Sizewell C (SZC)

Planning Inspectorate Reference EN010012

Written Summary of Oral Case

Issue Specific Hearing 11 Flooding, Water and Coastal Processes 14 September 2021

DRAWING TITLE:
MAIN DEVELOPMENT SITE SSSI CROSSING
(UNDER CONSTRUCTION - BAILEY BRIDGE STAGE)

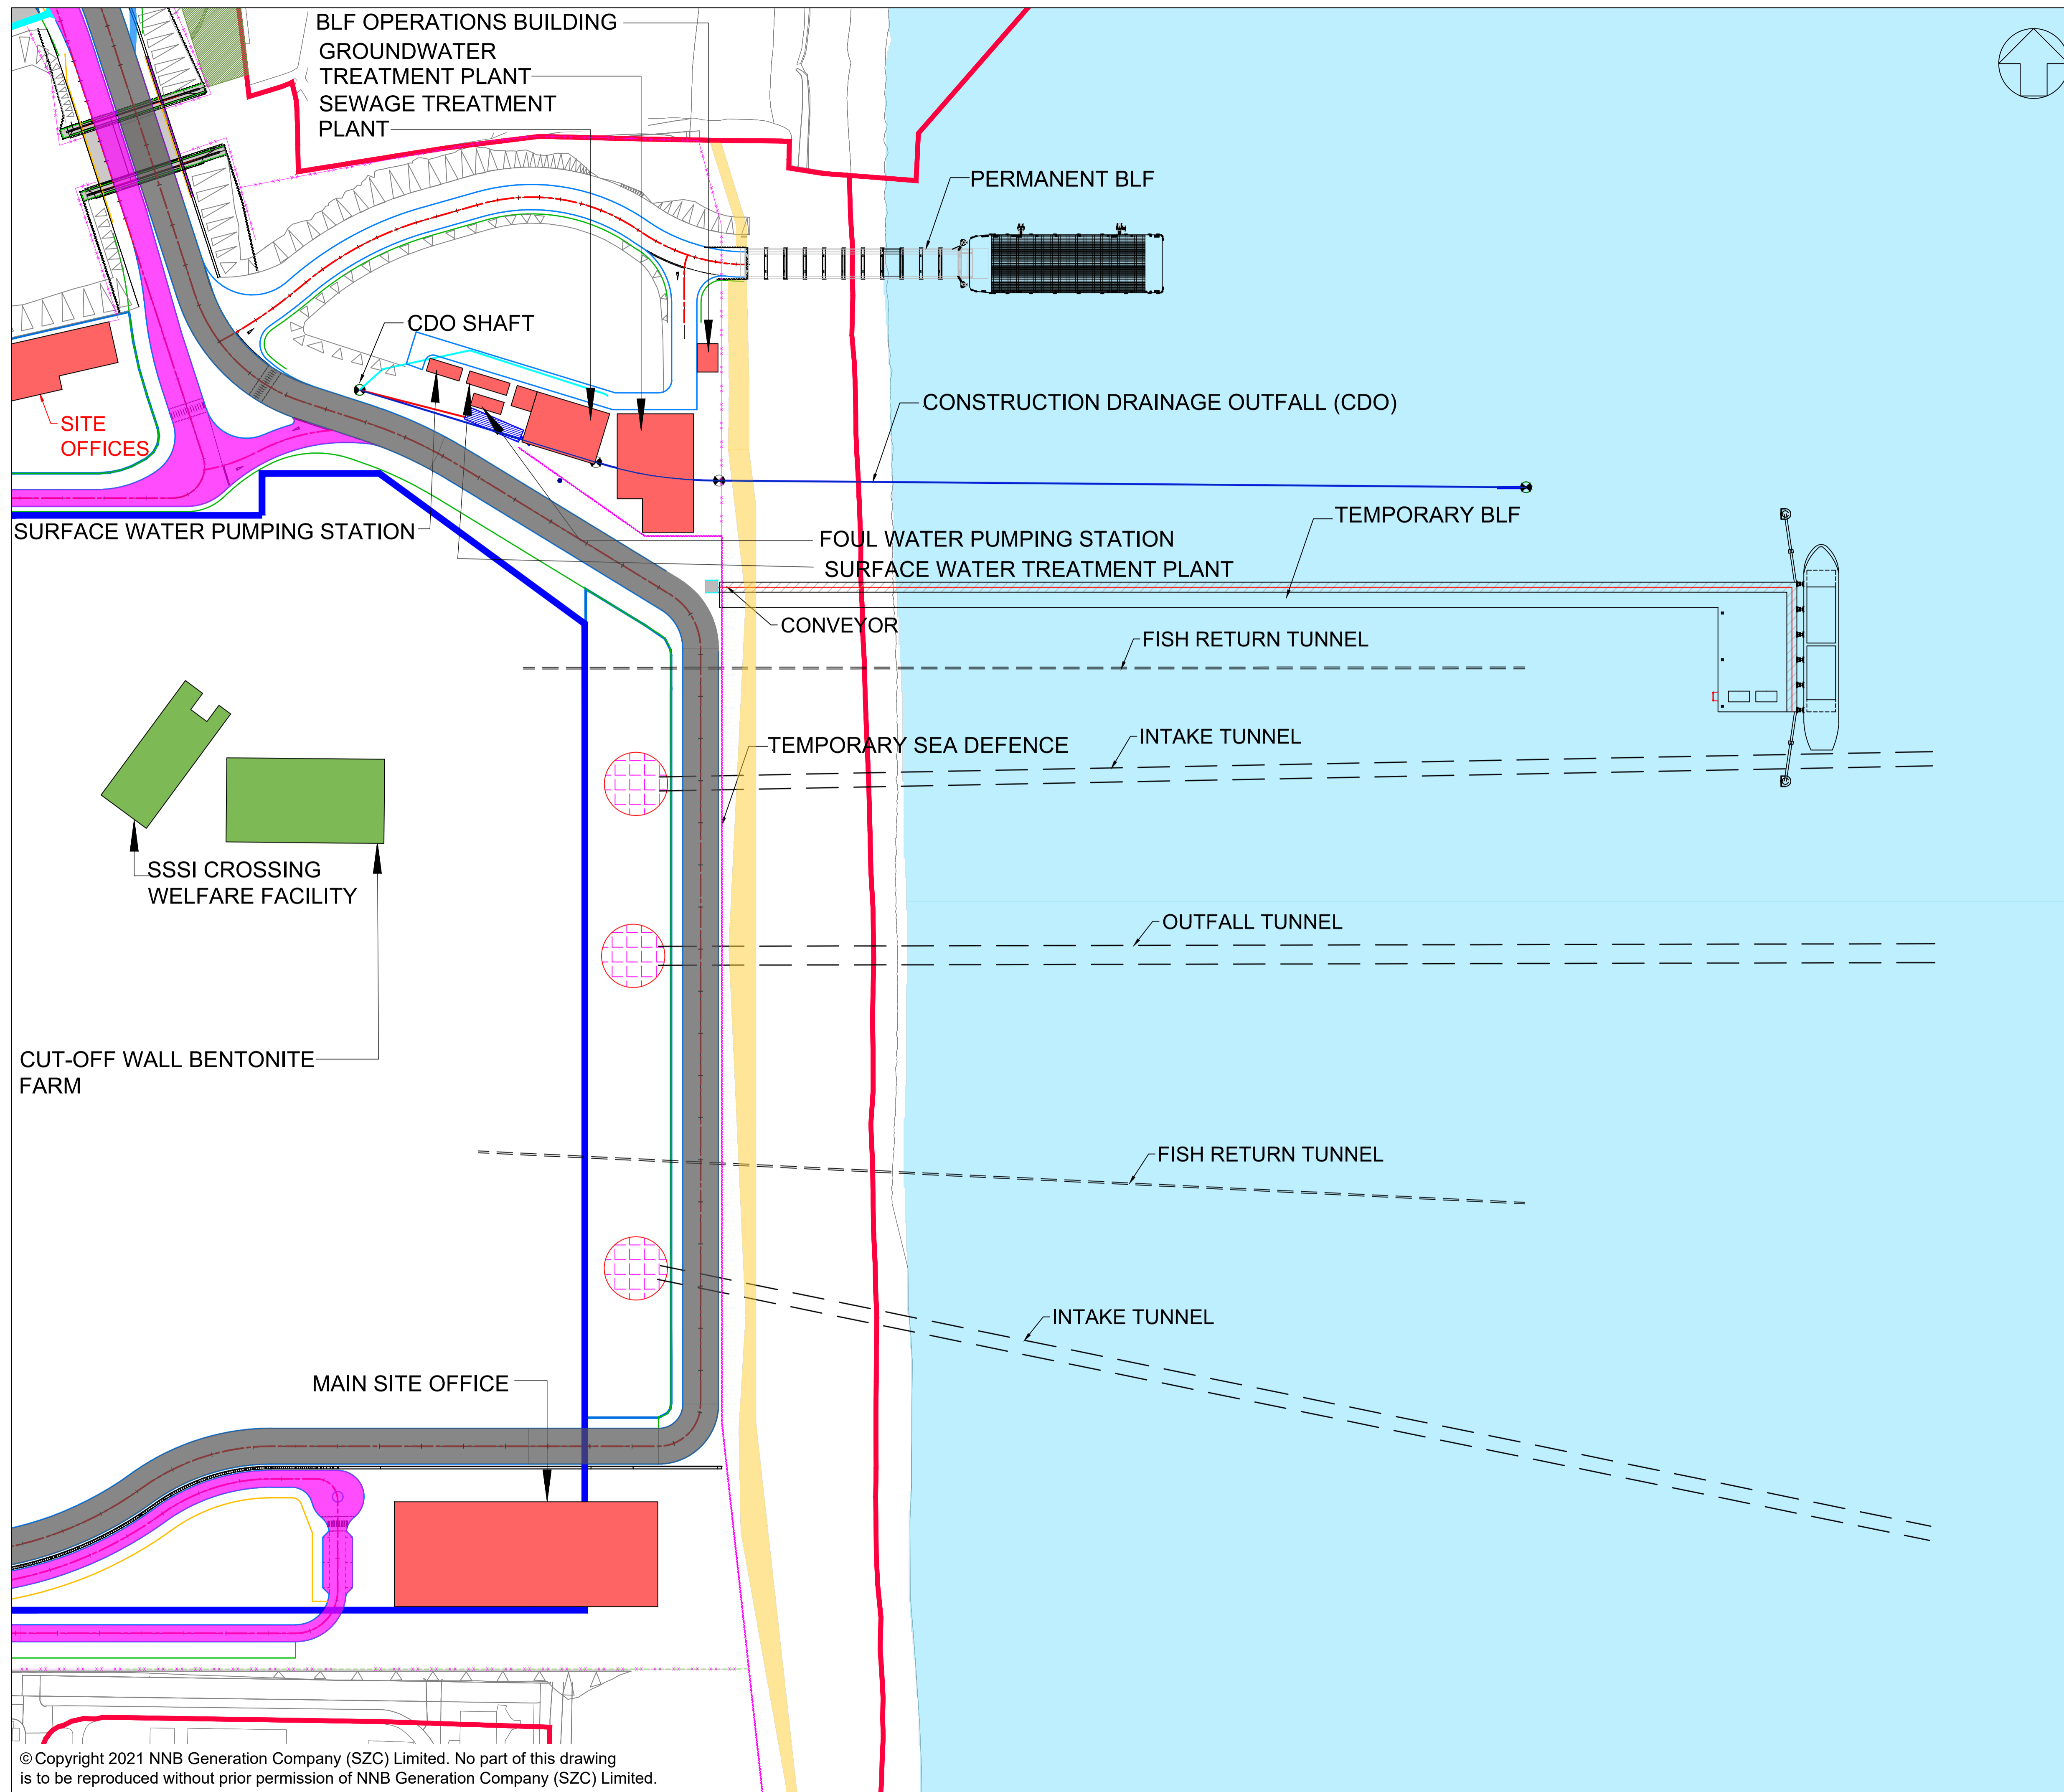
ESC would also like to raise a matter which does not appear to have been covered in the consultation documentation, if the proposed equipment is moved to the “subsequent location” in the TCA, will the pipes crossing the SSSI Crossing result in any changes to the design of the structure? It is noted that a lot of work has gone in to trying to ensure that the design of the SSSI Crossing minimises ecological fragmentation as far as possible and we do not wish to see this undone by needing to install more pipes over the crossing.
